COLORADO
Department of Transportation
Region 2

SH 24
El Paso County

RE: Meadowlake Ranch Sketch Plan_EA17227_SKP184 - **REVISED addition of Hydraulics Review/Q/A Response**

F.E.M.A MAP

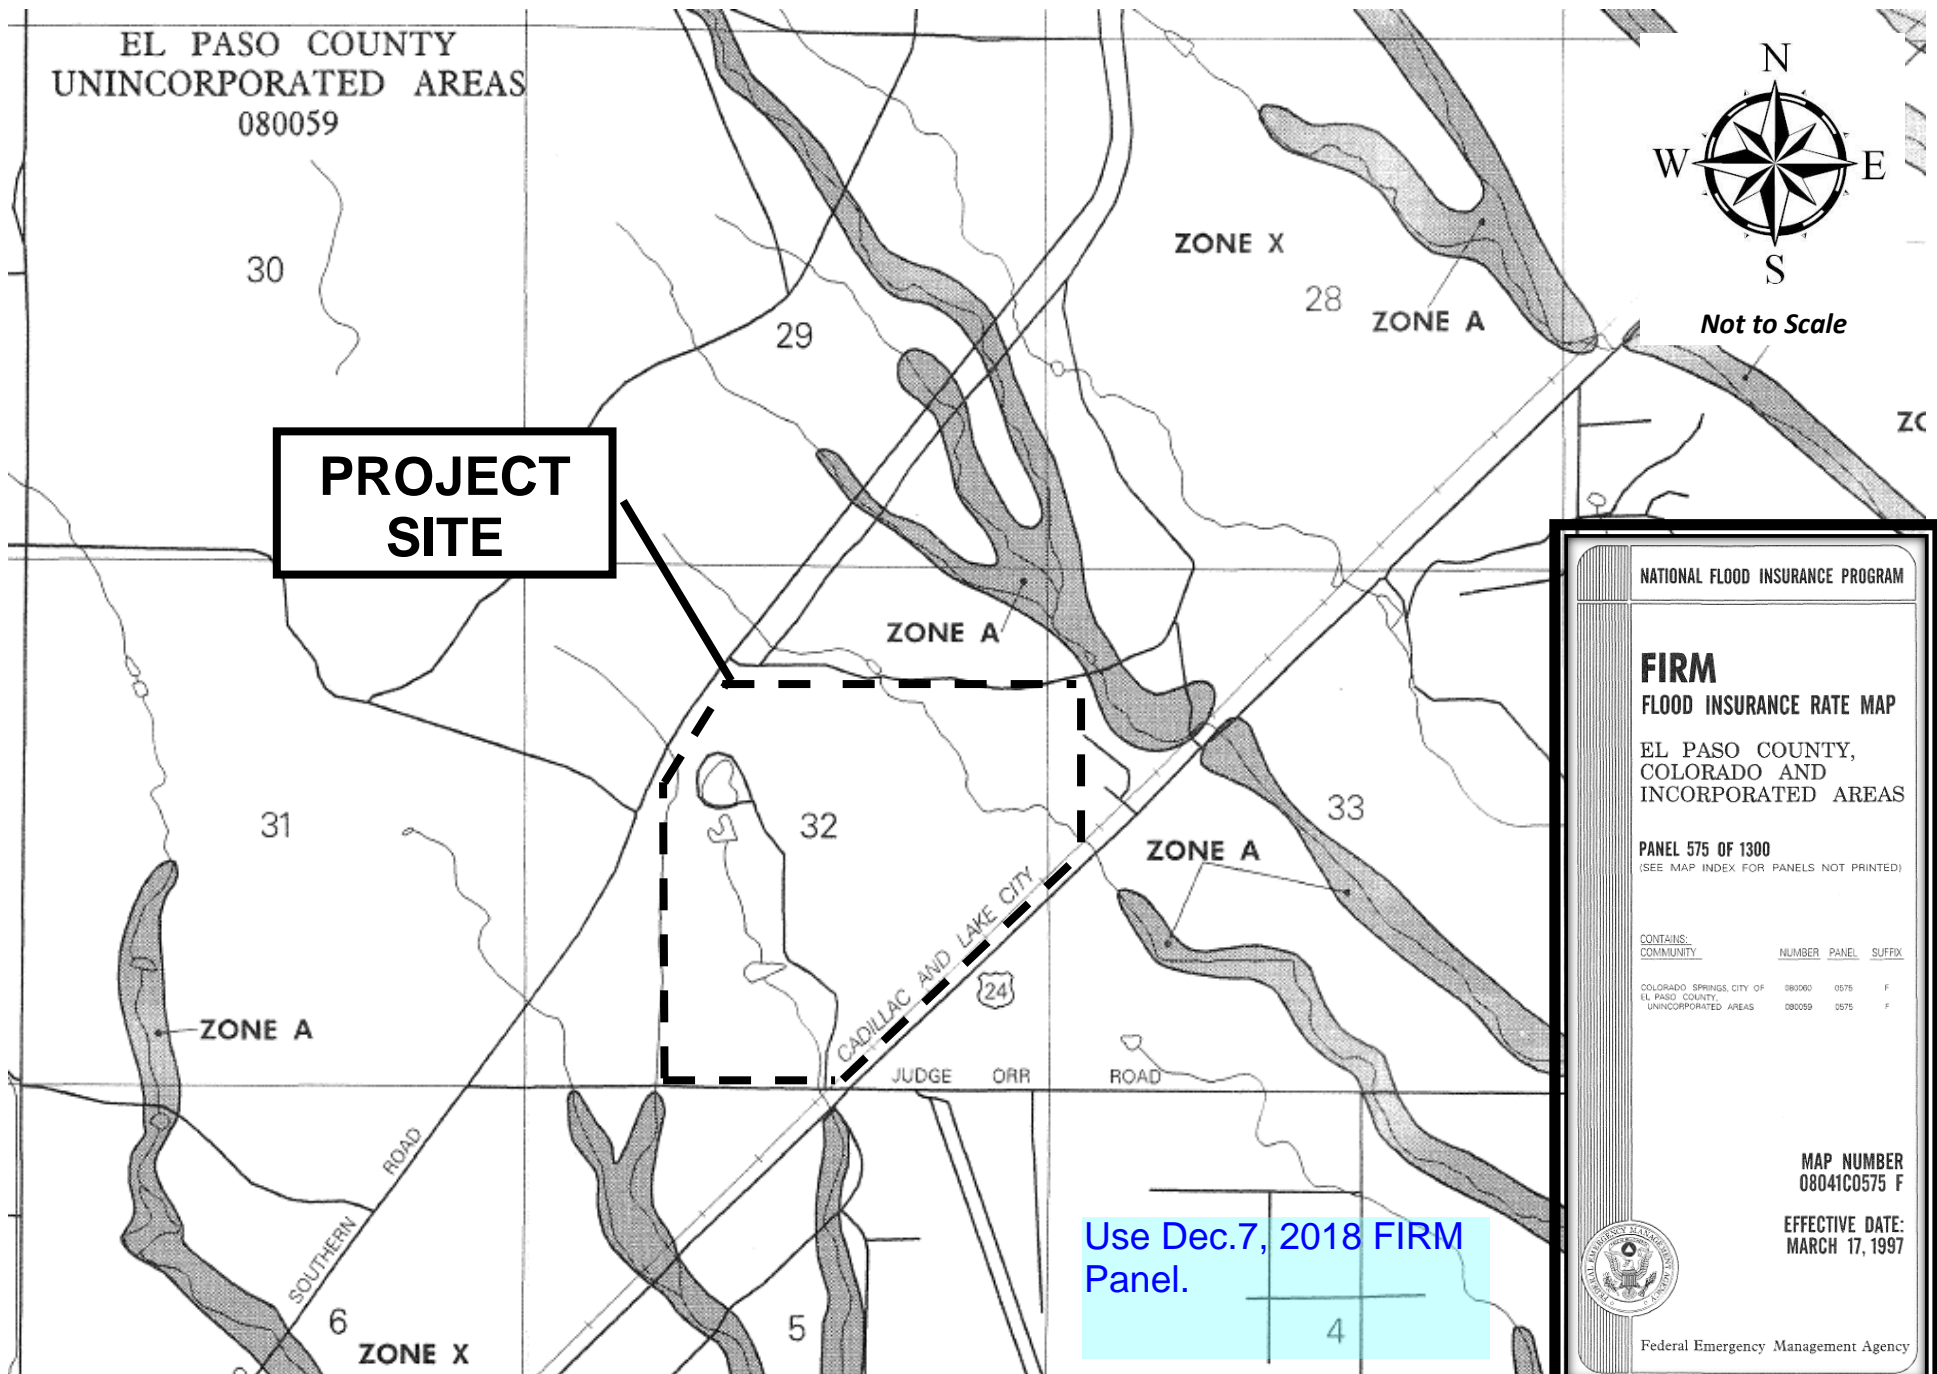
- c. Page 8 - Tributary area and runoff discharge should include the 63 acre wetland basin. This will require improvements downstream. However, this outfall seems to have been analyzed already, and recorded with FEMA. See attached FIRM map, effective December 7, 2018. Please update discussion of this basin.

- c. **Response:** As discussed above, the wetland/pond area will be retained in the proposed development and the berms regraded to attain the required runoff storage. The exact storage will depend on the development details, which are unknown at this time. The FIRM will be updated in the MDDP. The MDDP addresses the need for a detailed analysis of the Judge Orr Rd crossing, but such an analysis will be addressed in a future Drainage Report. The pertinent portion of the MDDP is included below.

Judge Orr Road – HW/D for 24” Pipe Culvert at Basin EX-1

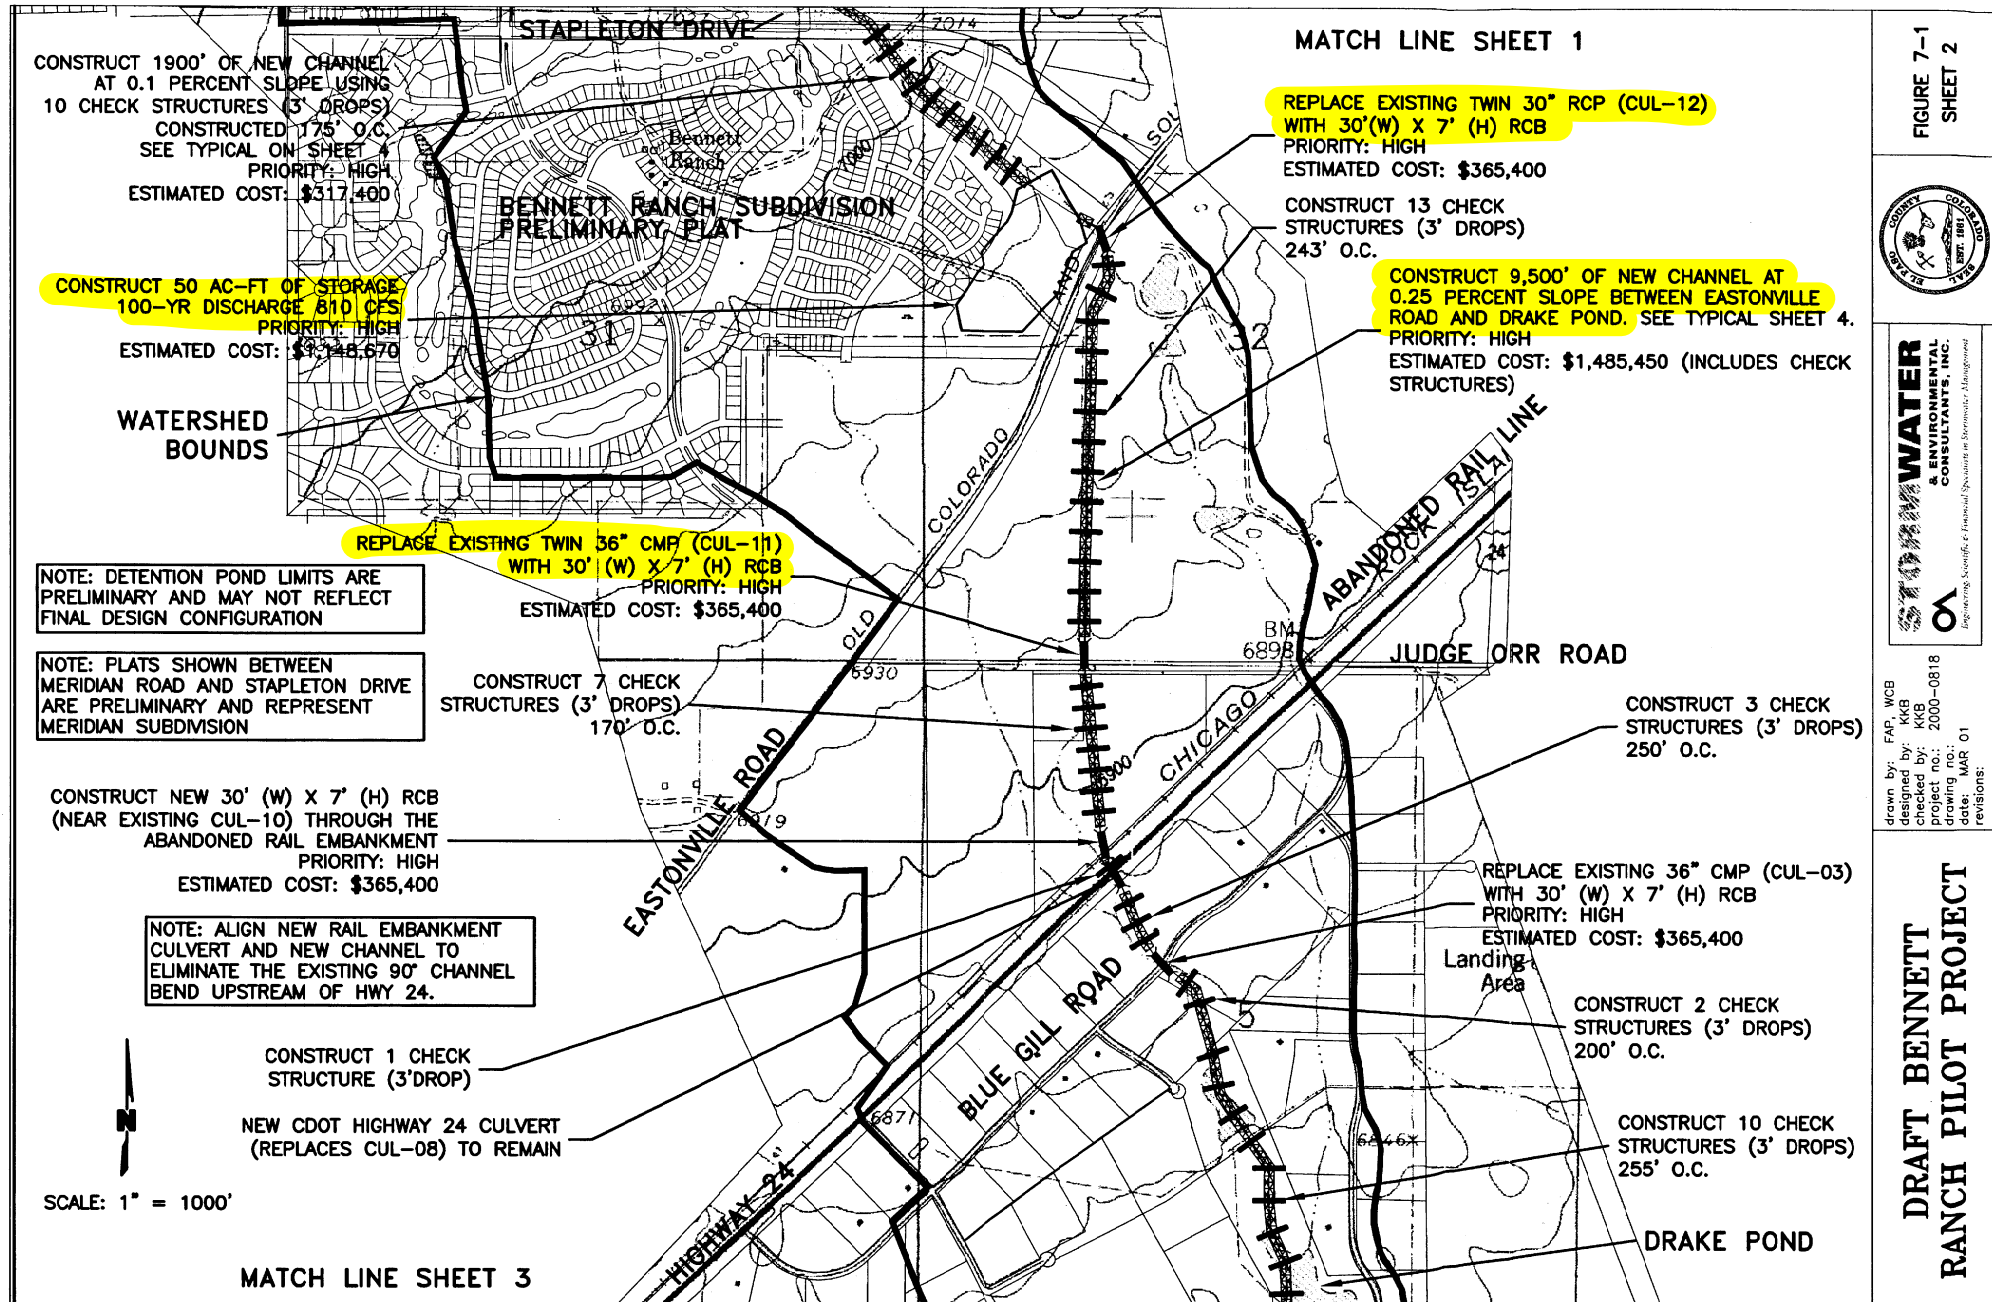
- b. Page 7 = Prove that this area doesn't contribute to downstream flows. Seems odd to eliminate basin area from analysis, especially since there is evidence of flows downstream of these wetland areas (natural swale, 24" CMP culvert under Judge Orr). Please show proof that this area can be removed from the hydrology.

- b. **Response:** The flow that crosses under Judge Orr Road downstream of the wetlands/ponds area comes from the drainage basin west of the wetlands/ponds. The ponds do not have outlet structures and the berms are vegetated and stable. El Paso County requested additional analysis of this area and a revised MDDP was submitted in early March. Below is the discussion from the revised report.
